Response to exhibition of Environmental Impact Statement for Proposed Two Staged Warehouse/Distribution & Light Industrial Facility, Burilda Close, Wetherill Park (SSD 7917)

- Report 'Environmental Impact Statement Horsley Drive Business Park, Proposed Two Staged Warehouse/Distribution and Light Industrial Facility, Proposed Lot 3 in Lot 5 DP1212087, Burilda Close, Wetherill Park', prepared by Willowtree Planning Pty Ltd on behalf of Frasers Industrial Constructions Pty Ltd, dated November 2016.

Figure 12: Proposed Landscape Plan

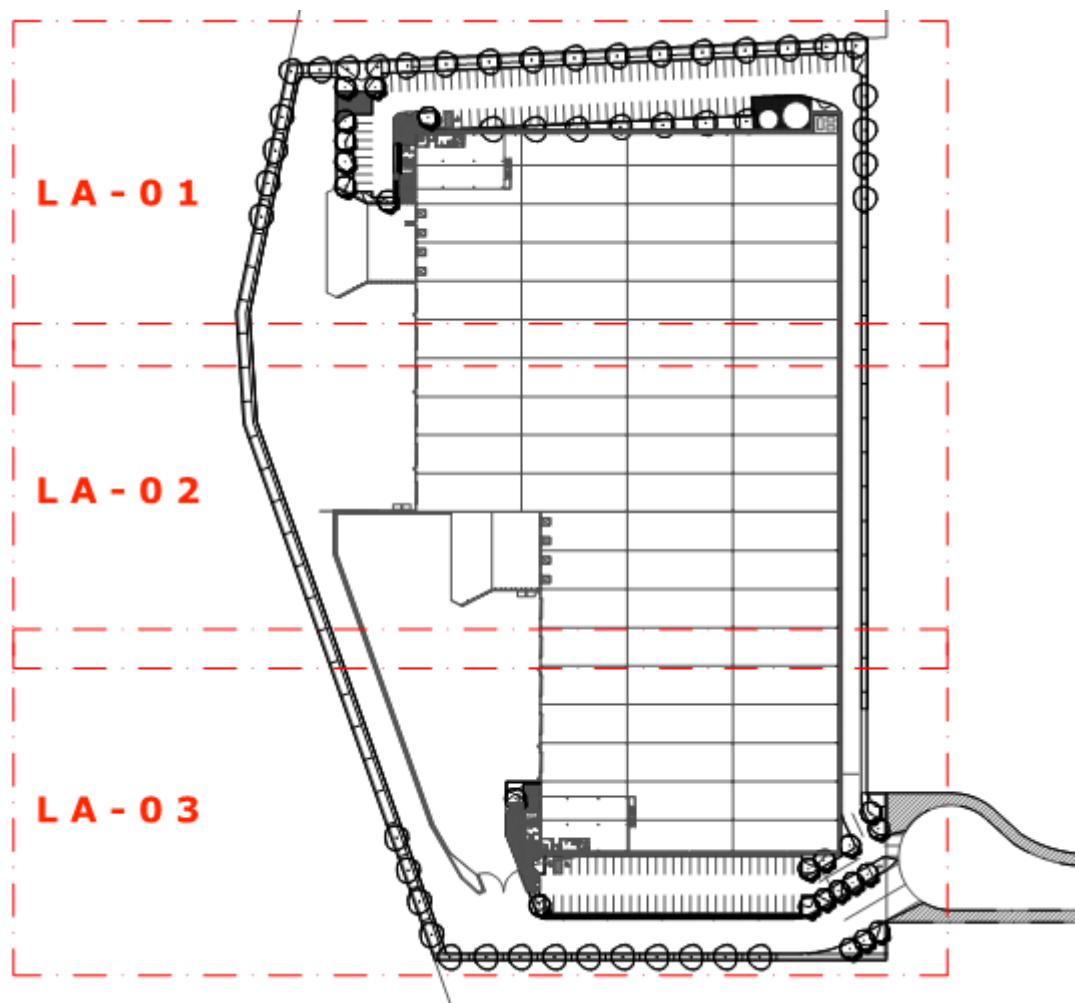
- Another mitigative design measure shall be defining a landscaped area to be developed on the subject site facing the Sydney Water Canal corridor as a soft barrier to protect the canal's visual setting.

Figure 13: Proposed site plan

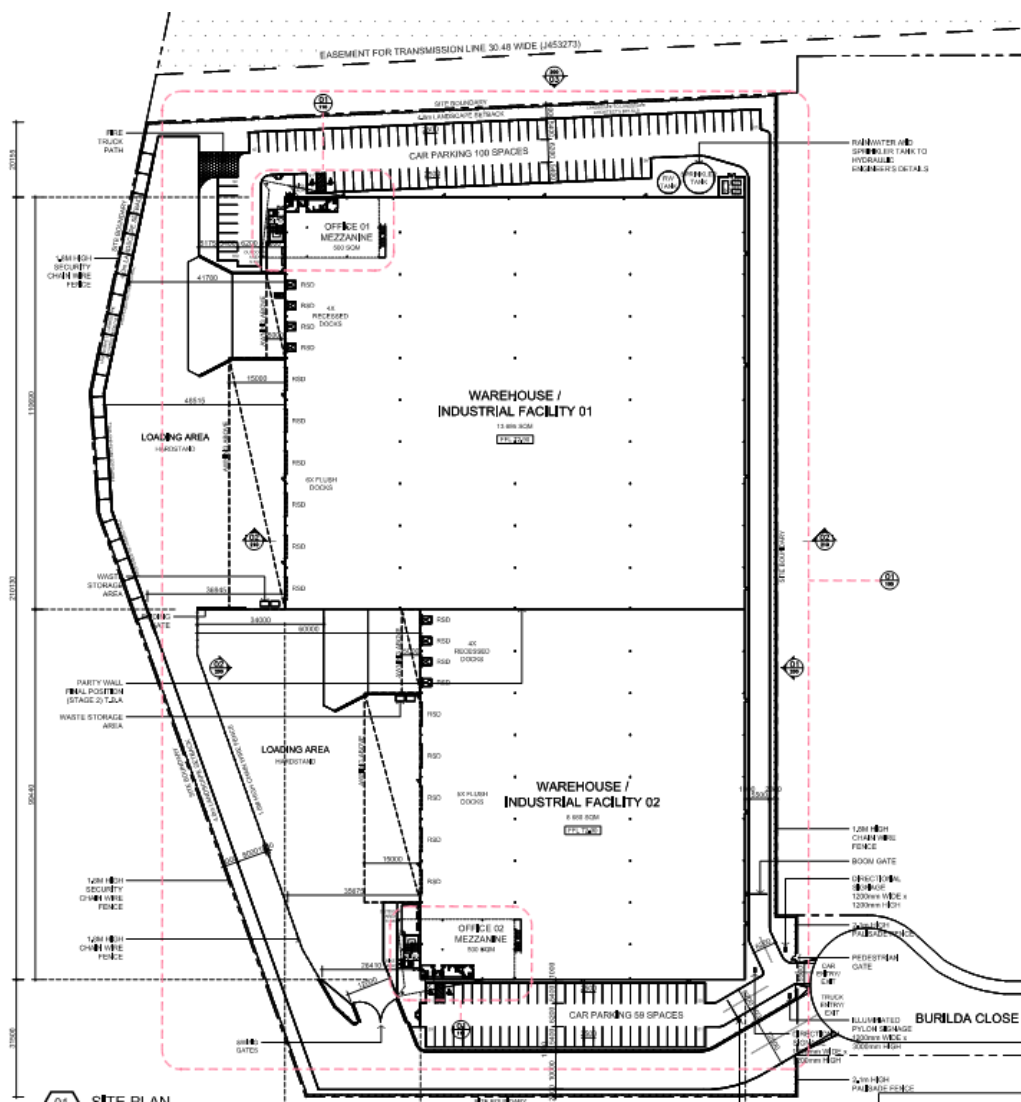
- Appropriate mitigative design measures should include appropriate building envelope setbacks from lots adjoining the Upper Canal, to ensure future applications do not have adverse visual or physical heritage impacts on the Upper Canal's heritage values.
